Request sketch plat review to vacate a public water and sewer easement from 3 existing lots, to create three new lots and grant a new public water and sewer easement further west from the vacated one. Utility plans for water and sewer, as well as the recorded IIA are provided.

Re: Sketch Plat Review for Subdivision to create Proposed Lots 2-A-1 thru 2-C-1, Tract S-1 of Atrisco Business Park, Unit 2, being comprised of Lot 2-A thru 2-C, Tract S-1 of Atrisco Business Park, Unit 2

Cartesian Surveys is acting as an agent for Ray's Flooring Specialist Inc. and we request a sketch plat review of our proposed subdivision to vacate an existing public water and sewer easement, creating three (3) new lots from three (3) existing lots: Proposed Lots 2-A-1 thru 2-C-1, Tract S-1 of Atrisco Business Park, Unit 2, being comprised from Lot 2-A thru 2-C, Tract S-1 of Atrisco Business Park, Unit 2. The property is located at 7401 Los Volcanes Road NW, between Ben Keith Way and Airport Drive NW.

Plat for
Lots 2-A-1 thru 2-C-1, Tract S-1
Atrisco Business Park, Unit 2
 Being Comprised of
Lots 2-A thru 2-C, Tract S-1
Atrisco Business Park, Unit 2
 City of Albuquerque
 Bernalillo County, New Mexico
 September 2024

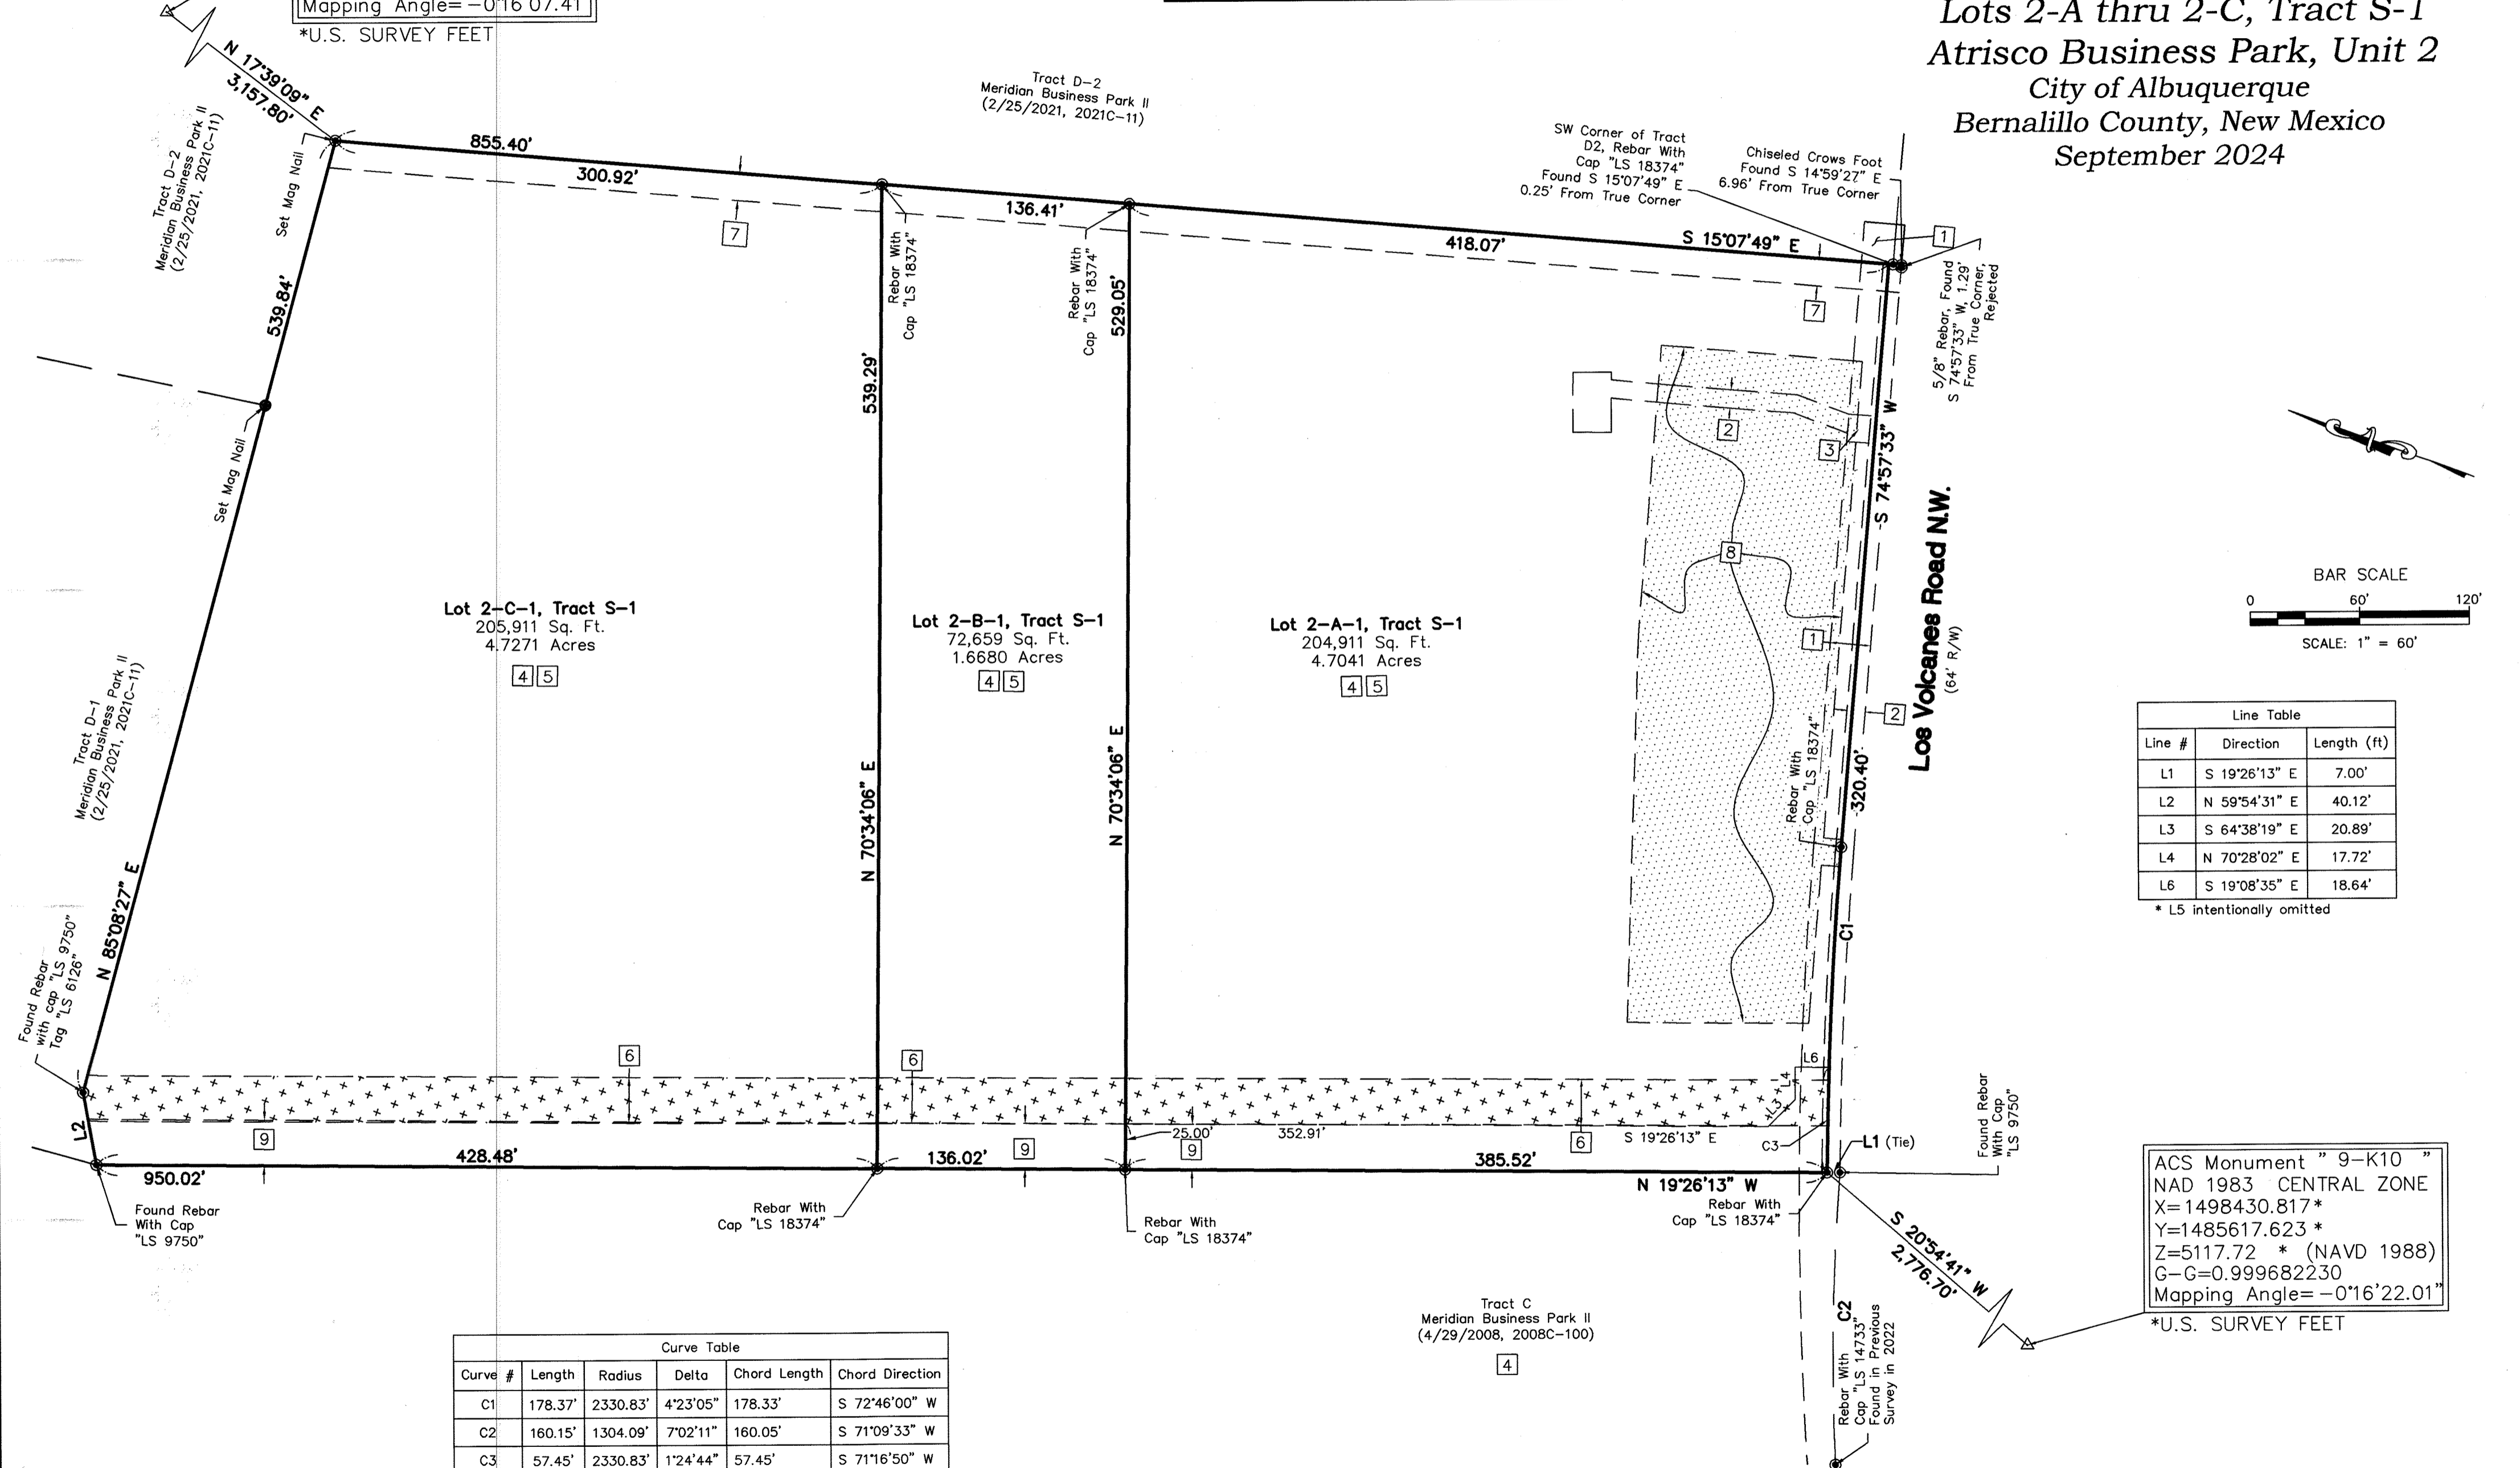
• The existing detention pond needs to be in a private drainage easement **with the drainage easement notes** showing maintenance responsibility for all three lots.

♣ Per Table 7.2.29 from section 7 of the DPM: Los Volcanes is a Major Collector. Requires a 6ft Sidewalk & 5-6ft landscape buffer. *Please confirm compliance, or waiver request, or DHO determination request?

Noted, the drainage easement language note requested was added to sheet 3 of the recorded plat.

Our platting action is dedicating 7 feet of additional right-of-way to become compliant to the sidewalk and landscape standards for Los Volcanes as a major collector. We no longer request a determination from these widths.

**AS102 TCL**

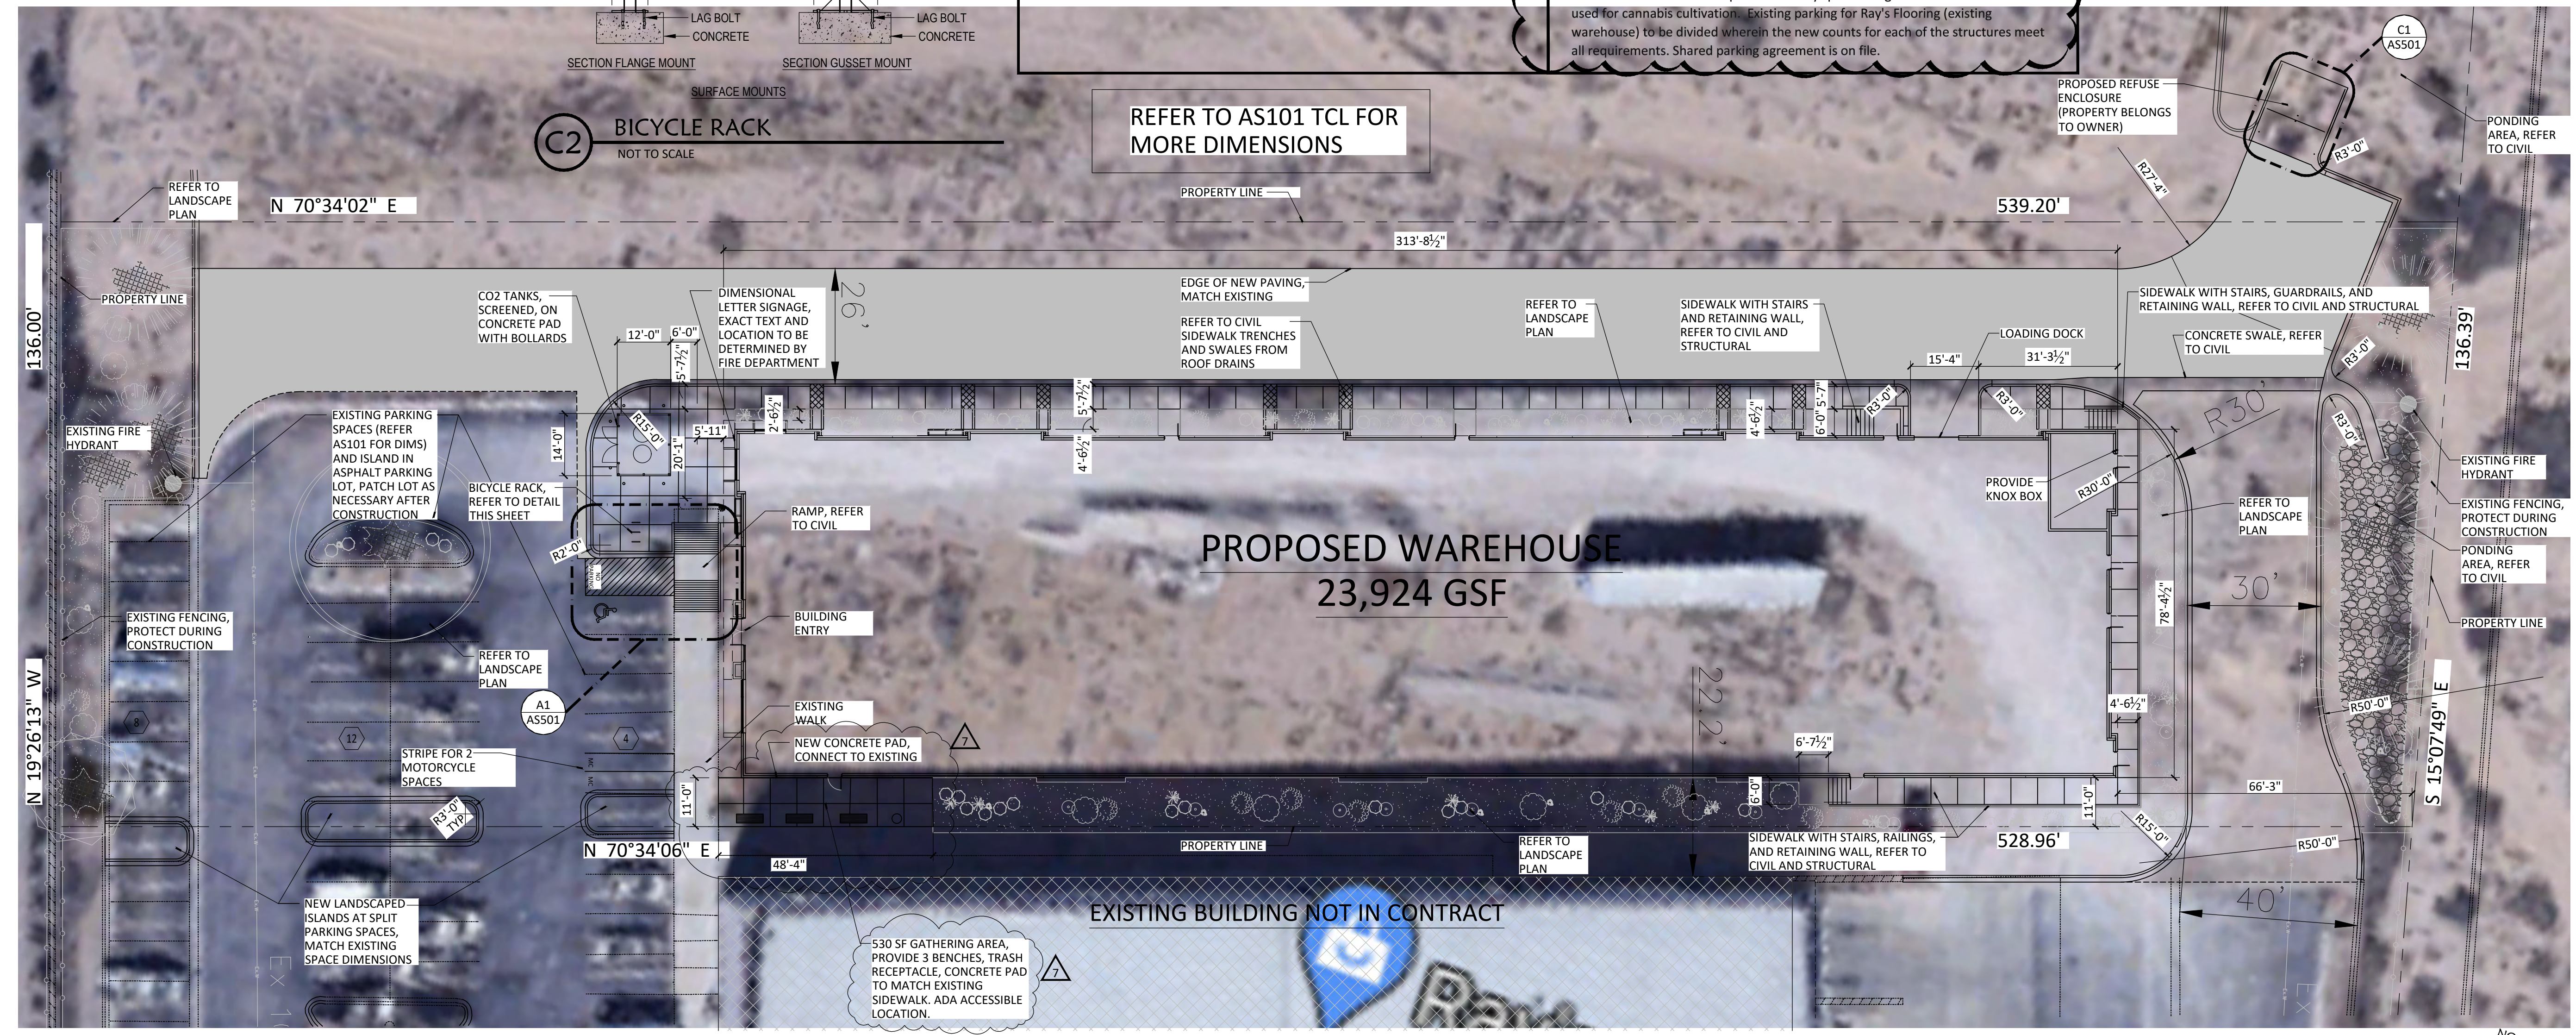
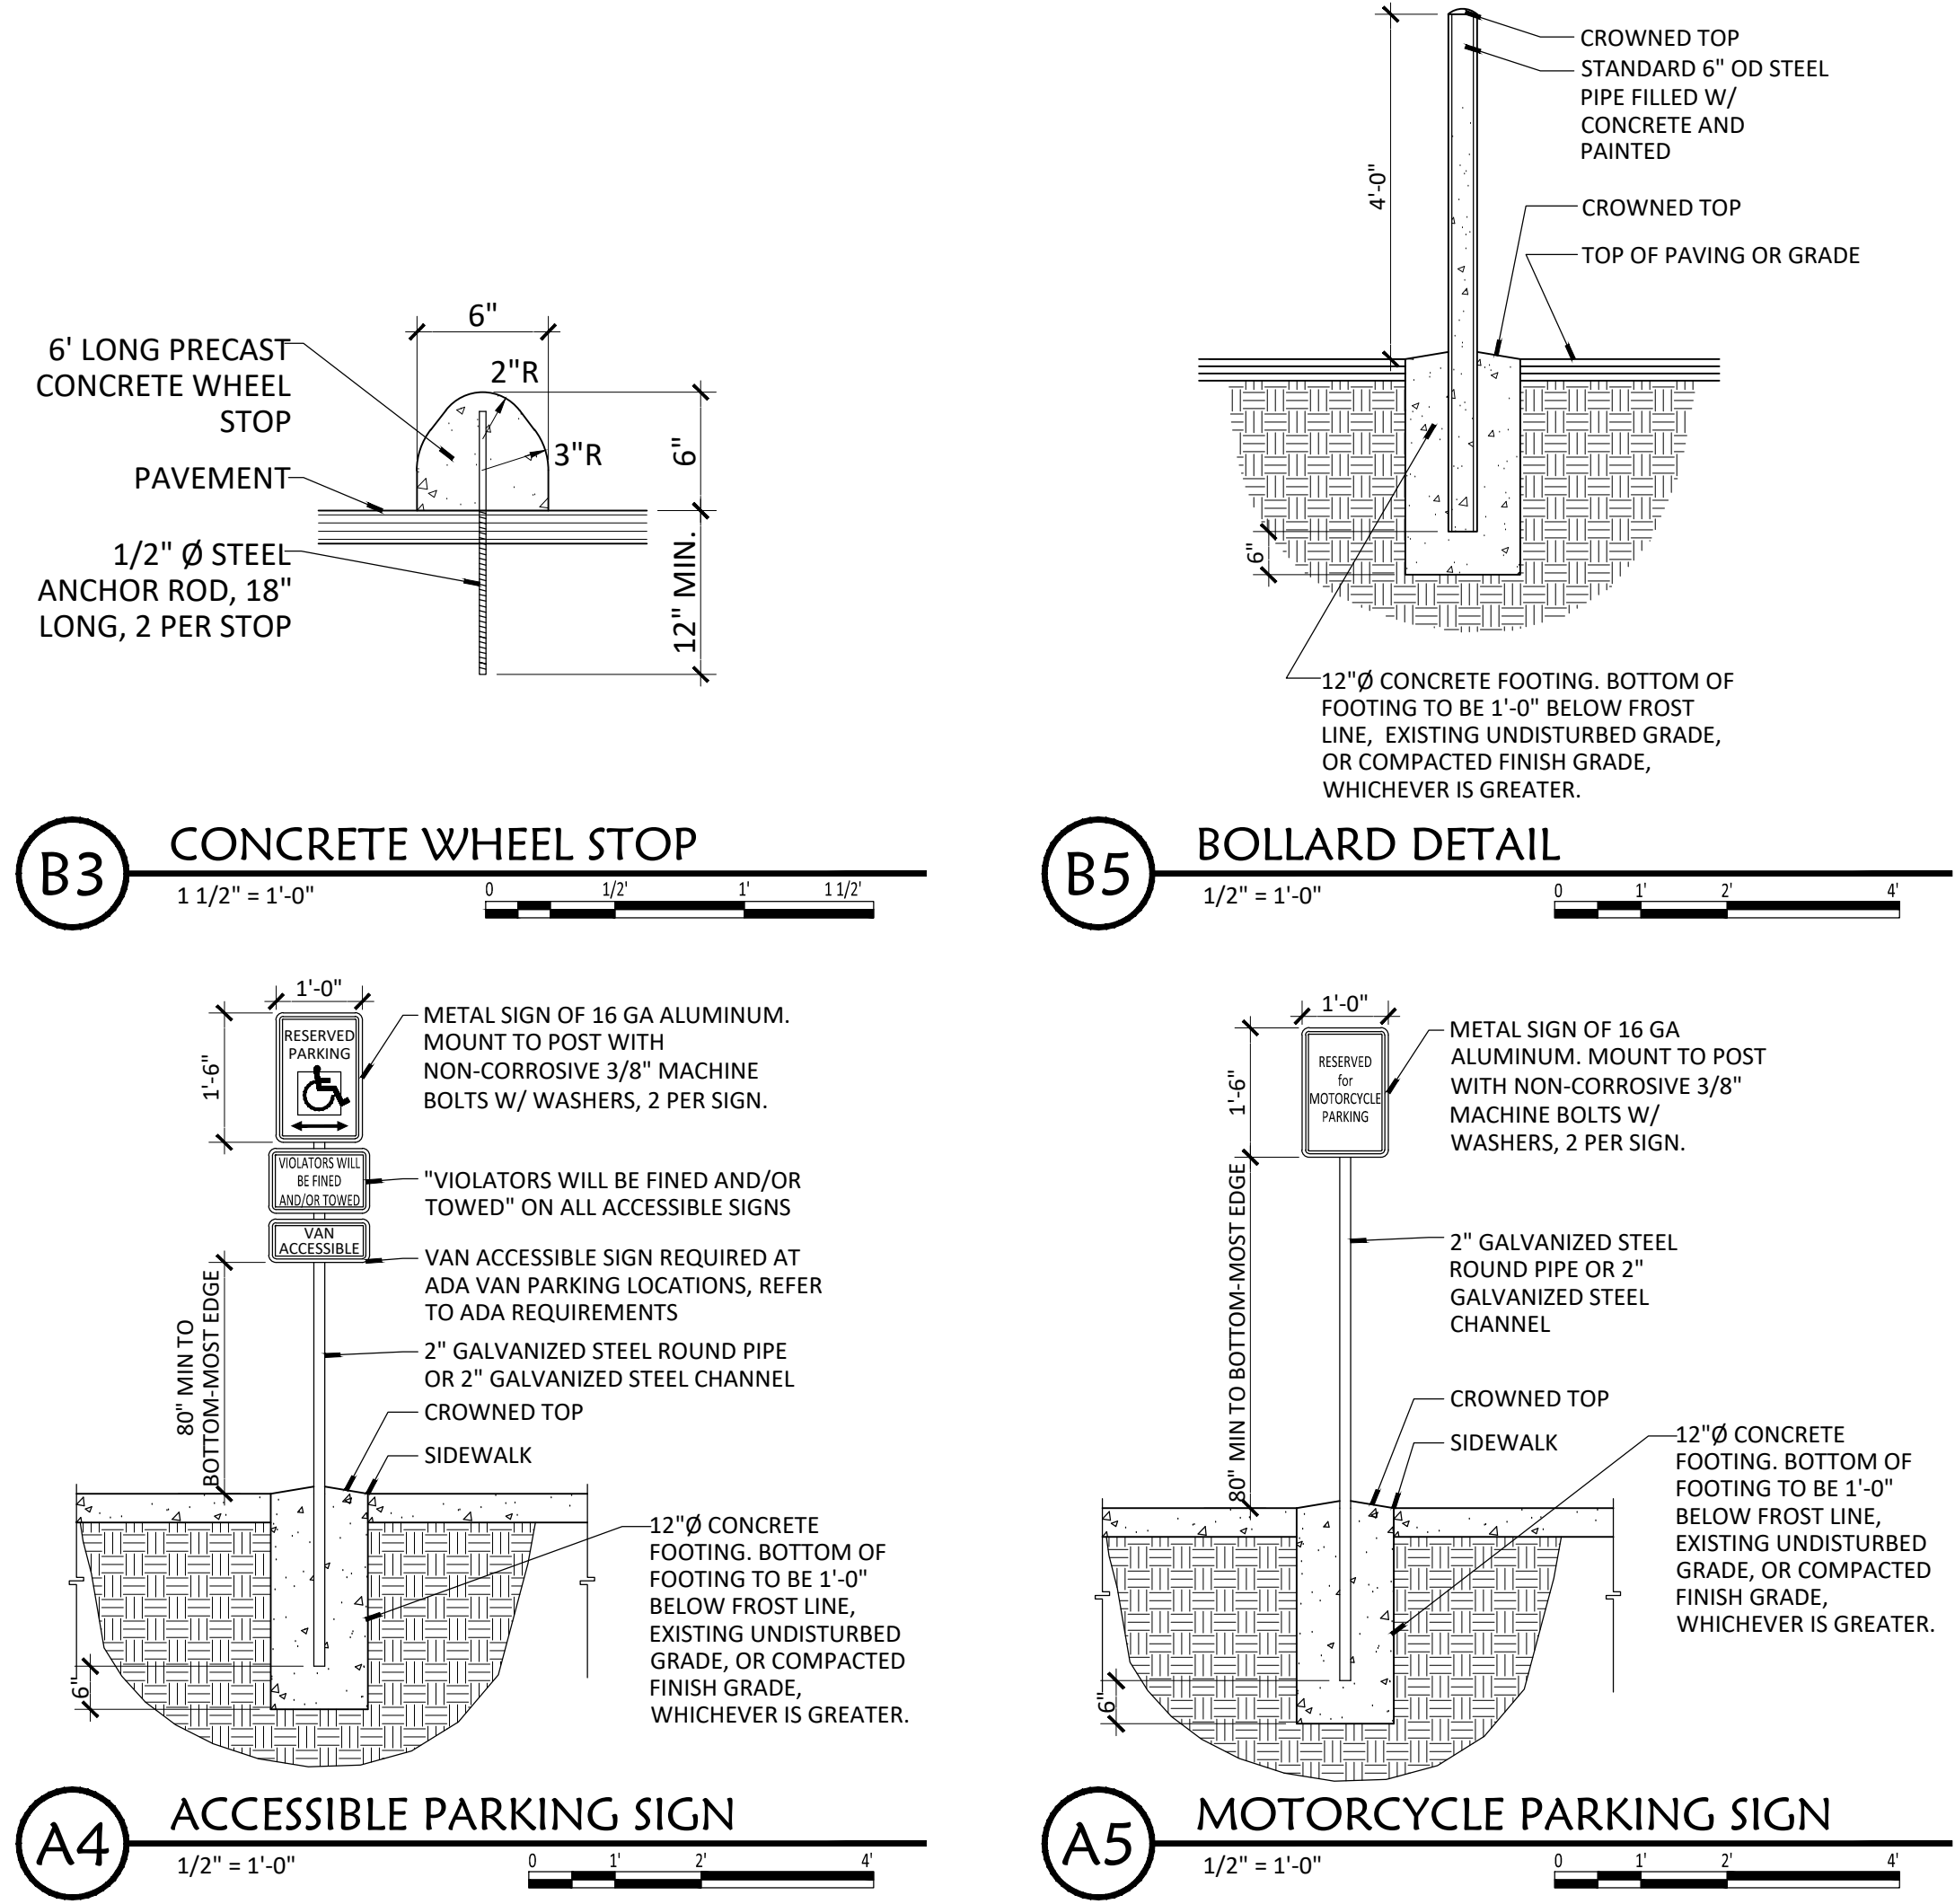
2. For any future development, a Traffic Circulation Layout will be required prior to Building Permit. Please ensure all lots meet parking requirements for the development currently on each proposed lot.

♣ Please clarify if parking and landscaping if affected by replat? Please confirm that parking and landscaping requirements are being met for the current site and if a shared parking agreement is a part of the new development?

Noted, parking counts are provided in the associated site plan attached and are covered by a parking agreement also provided in this supplement.

Noted, dedication of additional right-of-way to Los Volcanes Rd NW has been provided to accommodate 6-foot sidewalk and 5-foot landscape buffer. Parking requirements are shown to be met by a parking agreement, easement [5], and the attached parking counts from the anticipated site plan. See attached TCL pages and above explanation for code enforcement for specifics.
